162 Gillett Road, Thornton Heath, CR7 8SN

Design and Access Statement

Planning application – For proposed internal reconfiguration and refurbishment to increase the number of units with a change of use from 18 bedsits (previously) to a total of 23 HMO units.

Revision: A

DRAWING TITLE
Ground Floor
Existing & Proposed

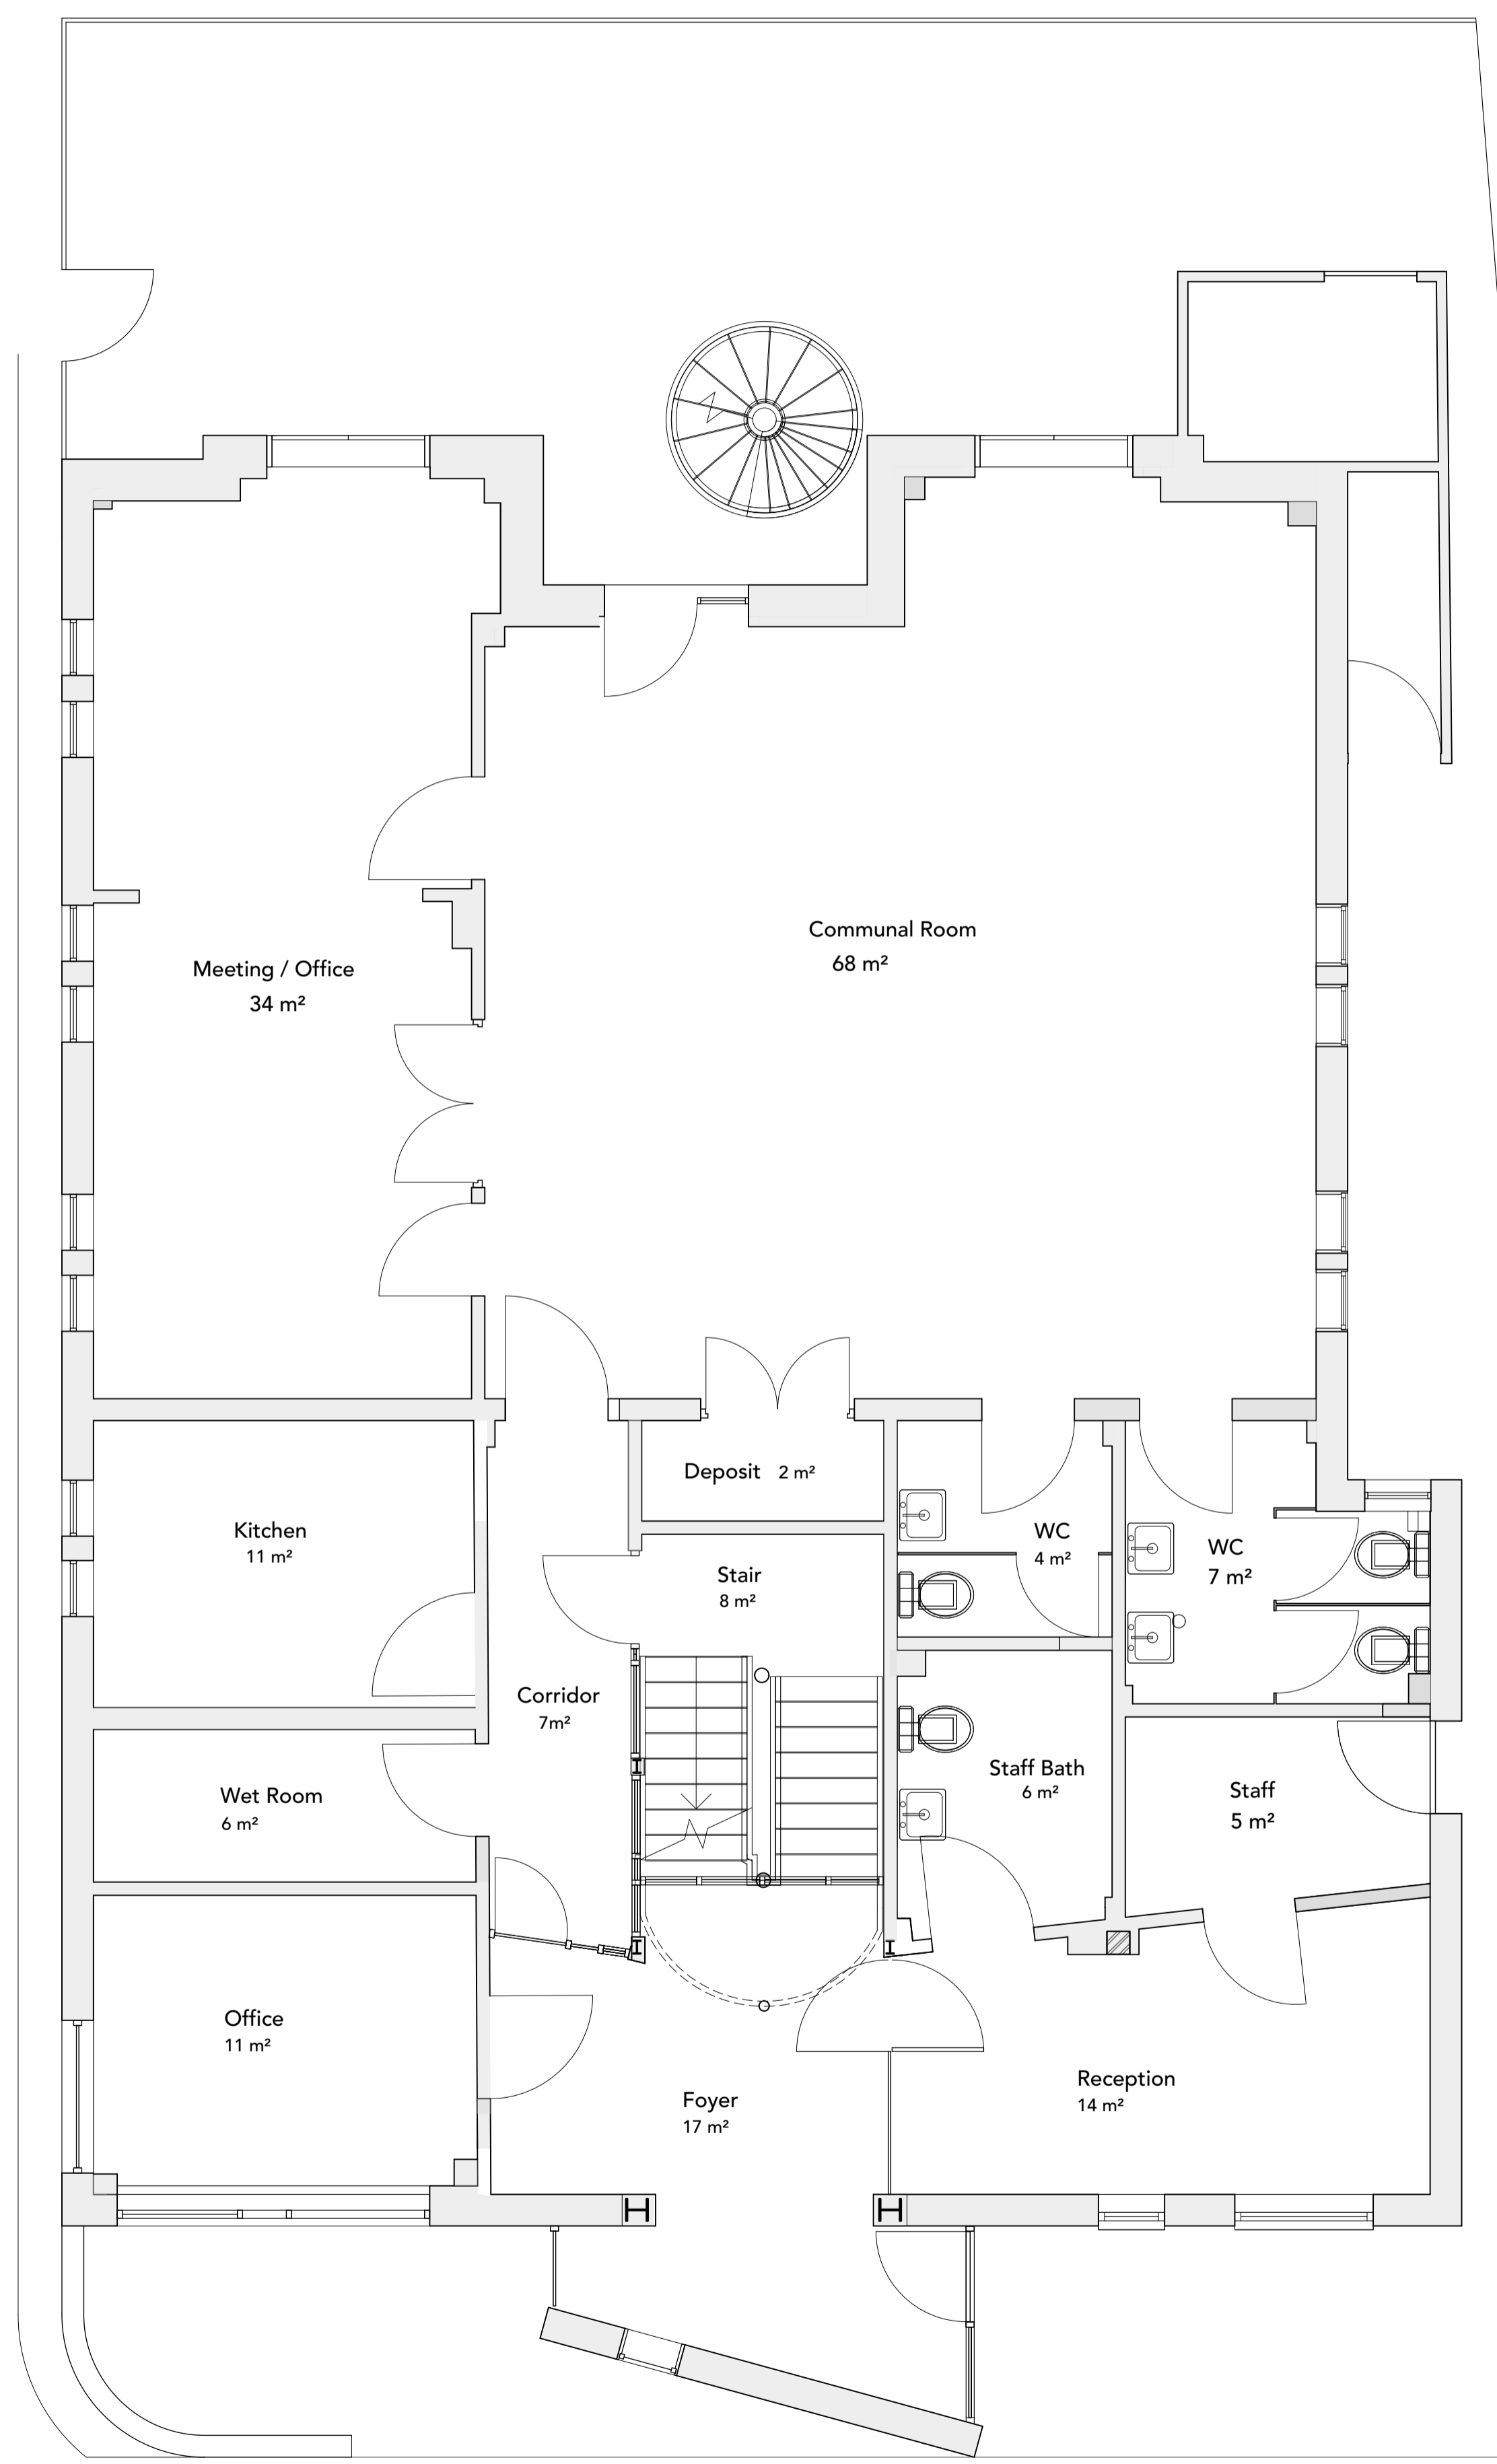
Officers comment (3): The applicant explained during the meeting that the proposed use would be a 'supported accommodation'. It is, however, notable that no space for support staff is shown on the plans and there is no communal space proposed. The plans suggest that the change of use is to self-contained bedsits in a type of accommodation that is more akin to a large HMO.

Response: The Ground Floor is designed to have a step free access. The 5 units on the ground floor are 'wheelchair adaptable'. Corridors and access through doors have been designed in order to allow wheelchairs to pass through.

Response: The scheme is for a change of use from an 18-bedsit supported living to a large HMO (23 units) with dedicated communal area and staff facility.
